## NSW RURAL FIRE SERVICE

Our reference DOC17/98017

### **Submission to the to the Woolgoolga to Ballina Pacific Highway Upgrade Project Modification 4 - Moonimba Quarry Development Application Modification**

Current Access to
Communication
Facilities

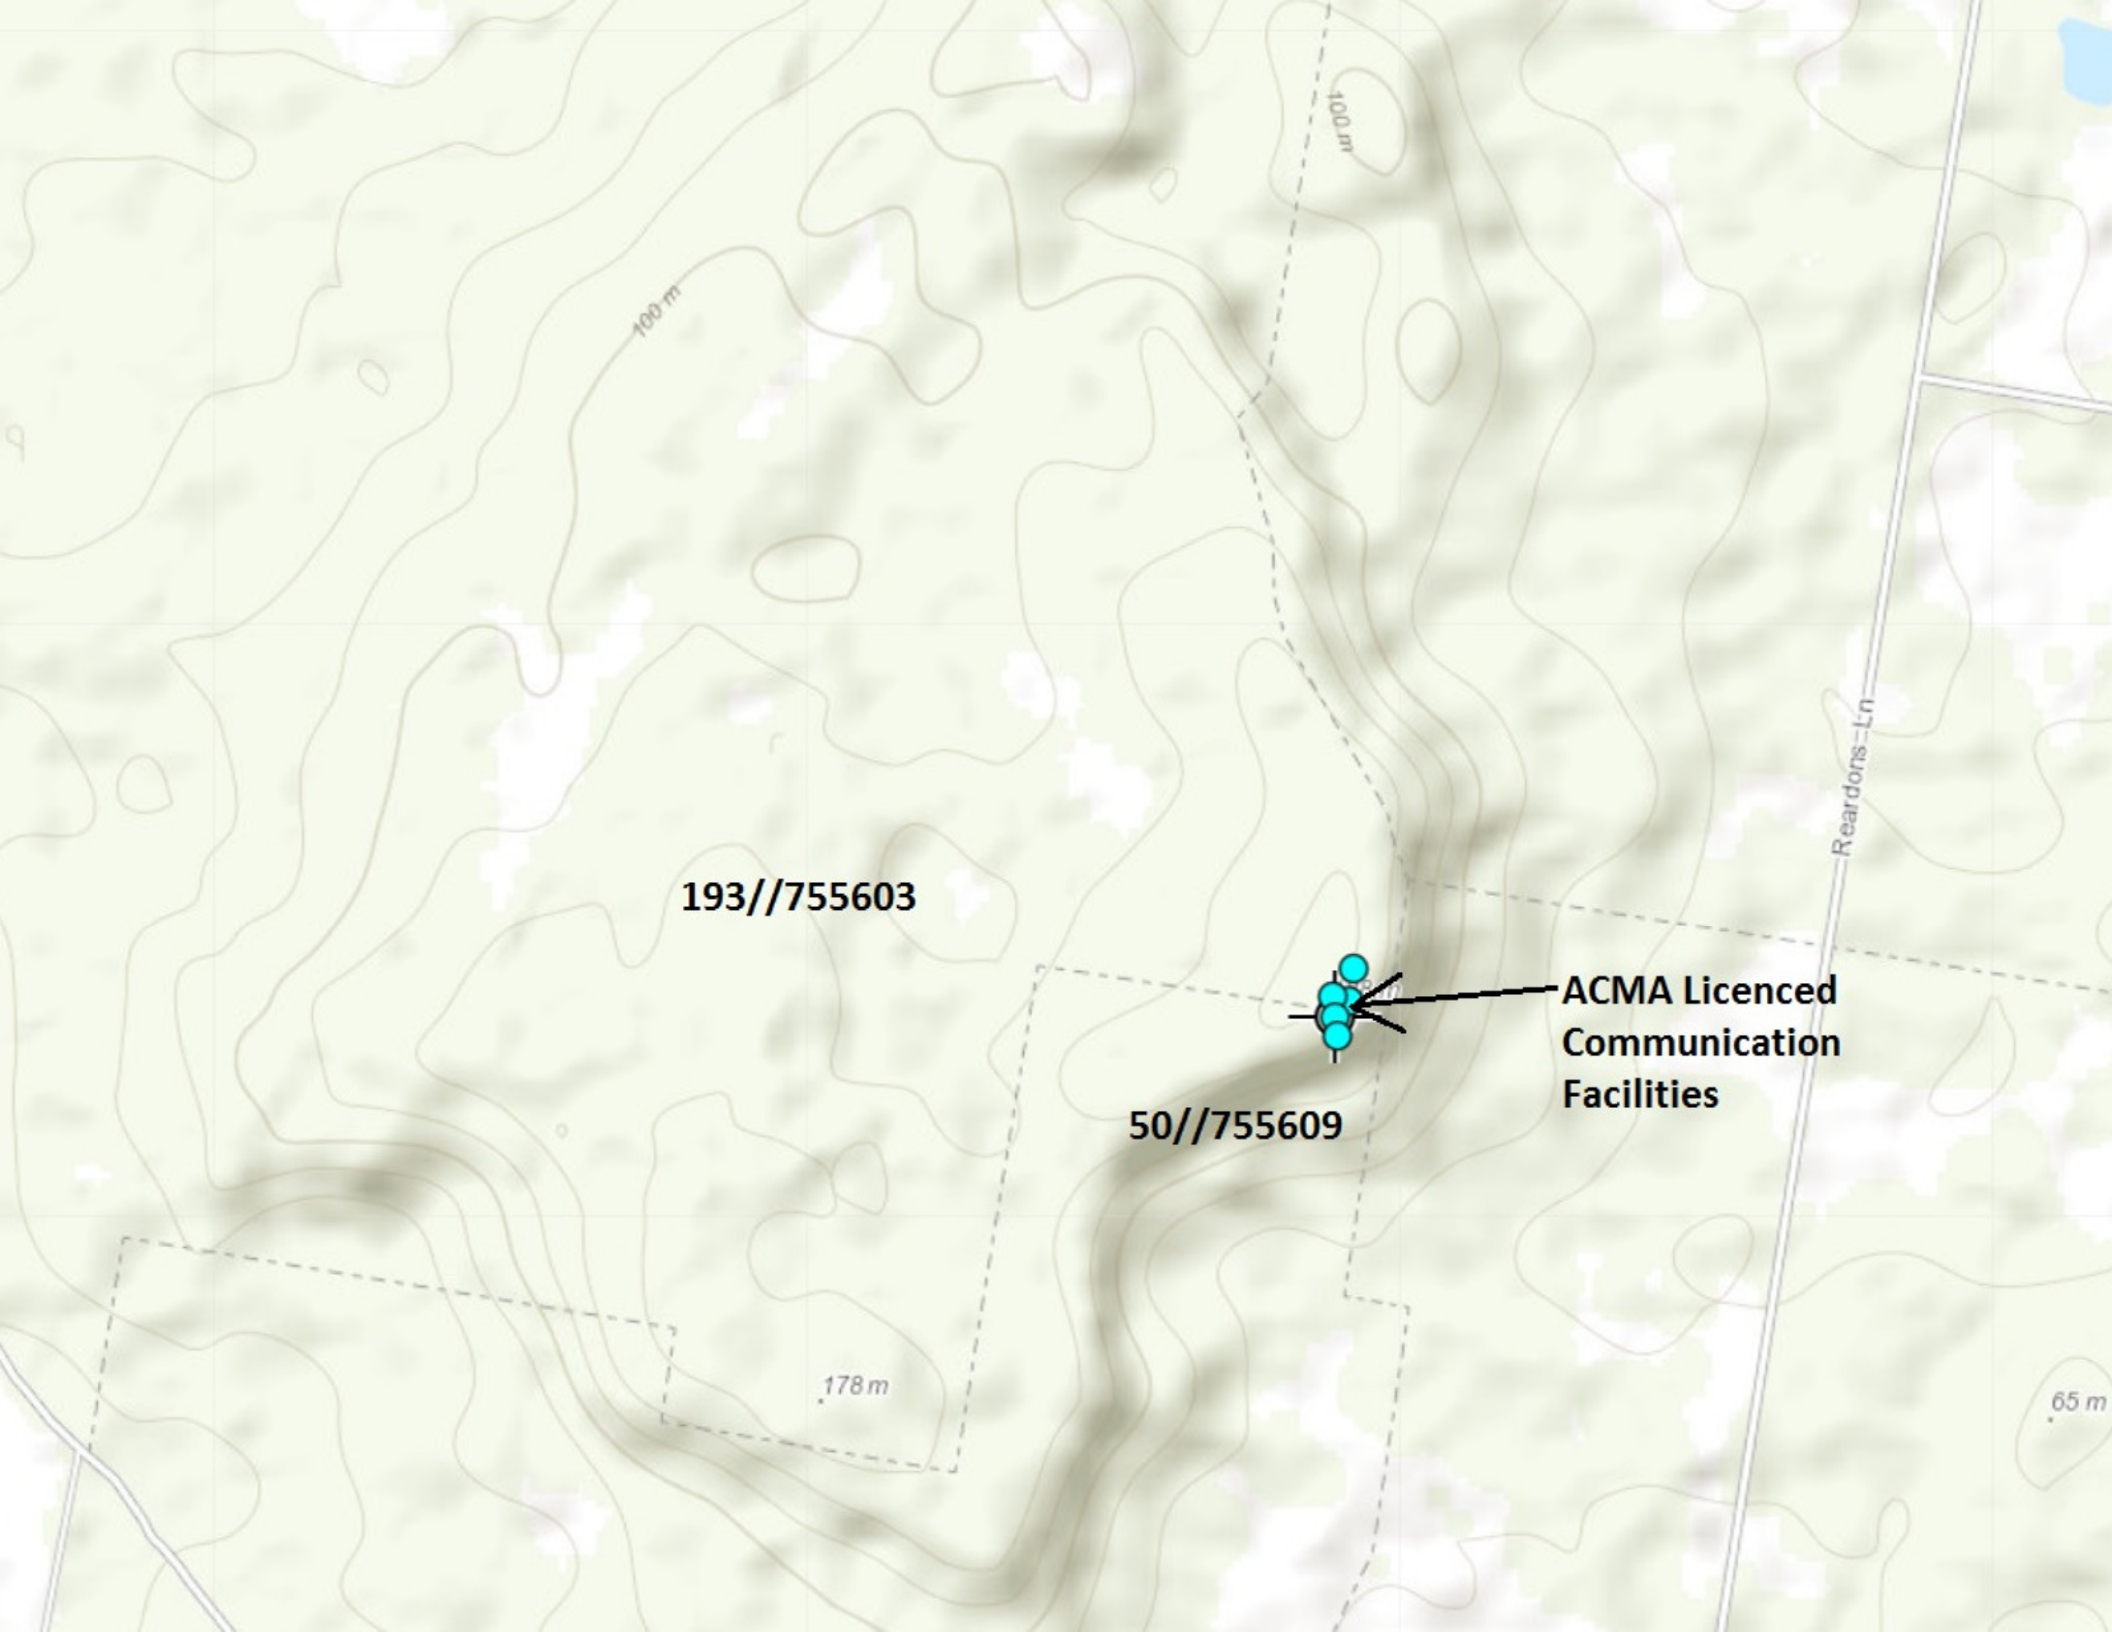
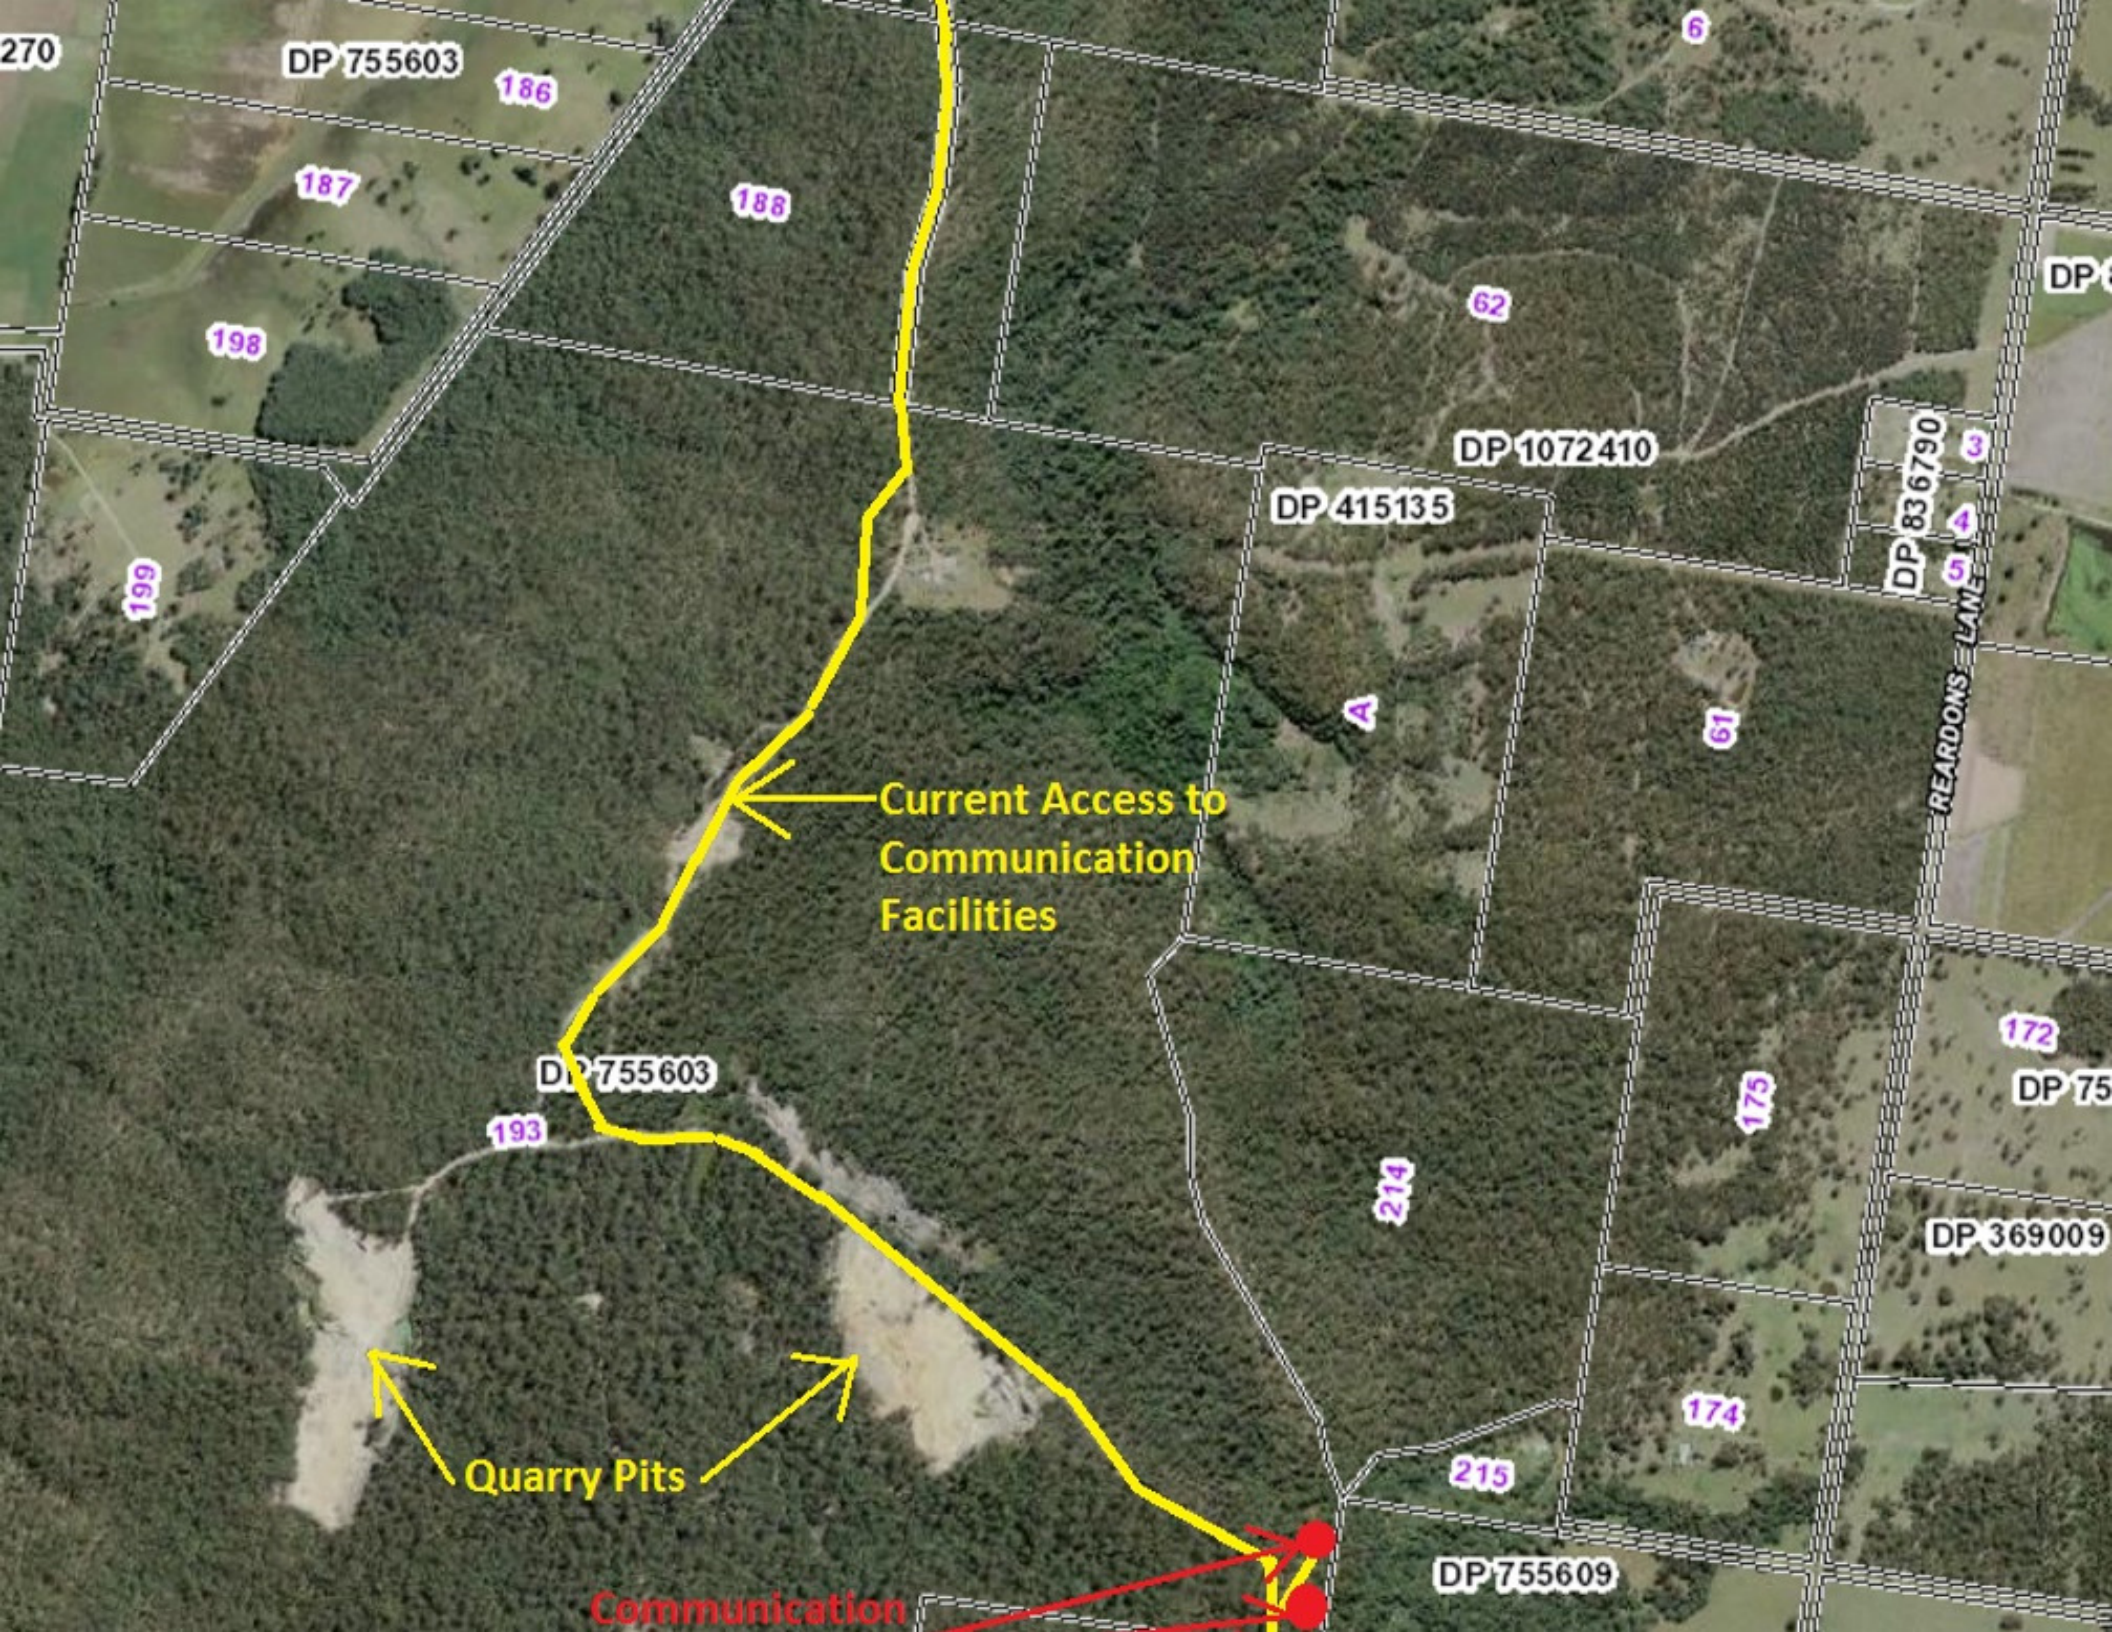
Therefore, the RFS requests that the development consent ensures we have continued unfettered access to the radio sites during the quarrying activities. This could be through the existing or another constructed suitable road. Also an access management plan/protocol needs to be established between the quarry operators and the communication facilities users, so as access can be managed around

blasting and other quarry site activities that might restrict access for short periods. The RFS have no objection with the quarrying activity, providing access to the communication facilities is maintained.
